TOWN AND COUNTRY PLANNING (CONTROL OF ADVERTISEMENTS) (ENGLAND)
 REGULATIONS 2007

Address: 10 Gees Court, London, W1U 1JJ,

Proposal: Display of a non-illuminated projecting sign measuring 50cm x 60cm; a non-illuminated fascia sign measuring 20cm x 90cm; and an awning measuring 470cm x 180cm.

Thank you for your application received on 31 October 2023. I am writing to inform you that your application is incomplete for the following reason(s):

03SECTION1:100 @ A3

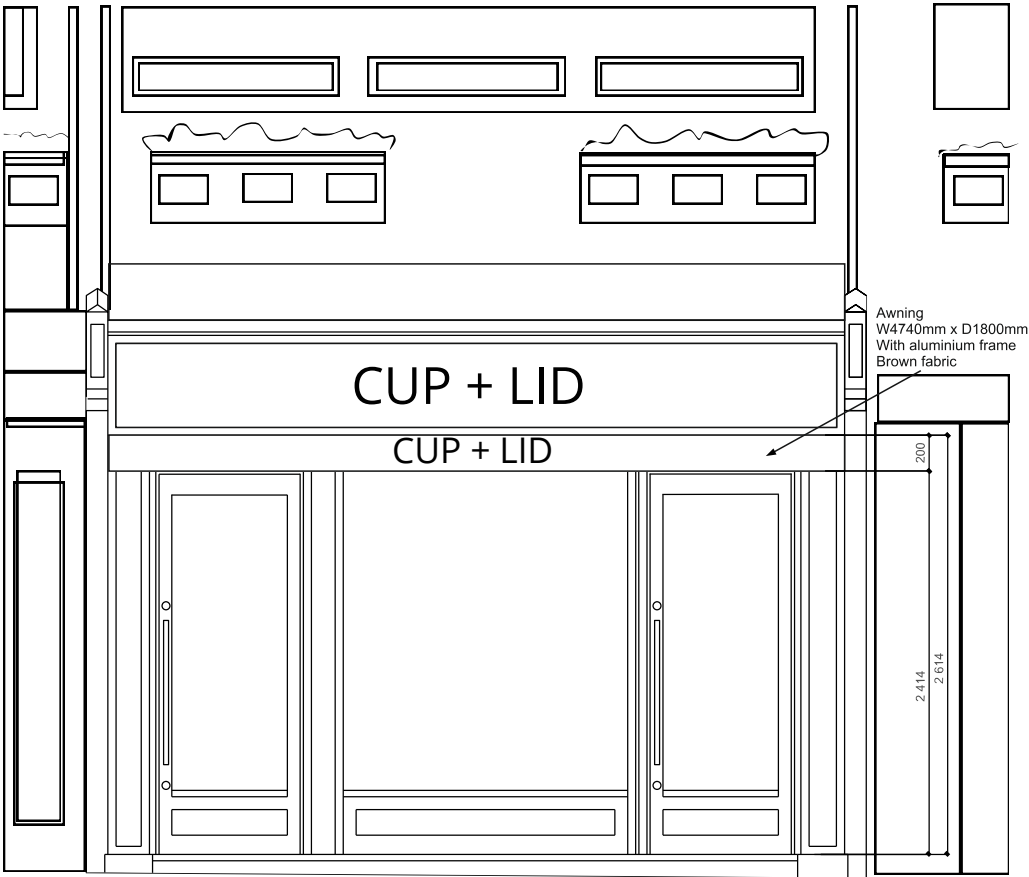
- 1 The existing and proposed drawings are not clear - please provide a unified set of existing and proposed elevations and sections - the proposed sections must show all signs including the awning at full extension. Please provide the necessary drawings showing fully and clearly what you are applying for. Your plans and drawings must be accurate and drawn to a recognised metric scale, include a scale bar, with any precise dimensions stated for important details. You must give each plan a distinctive reference number.
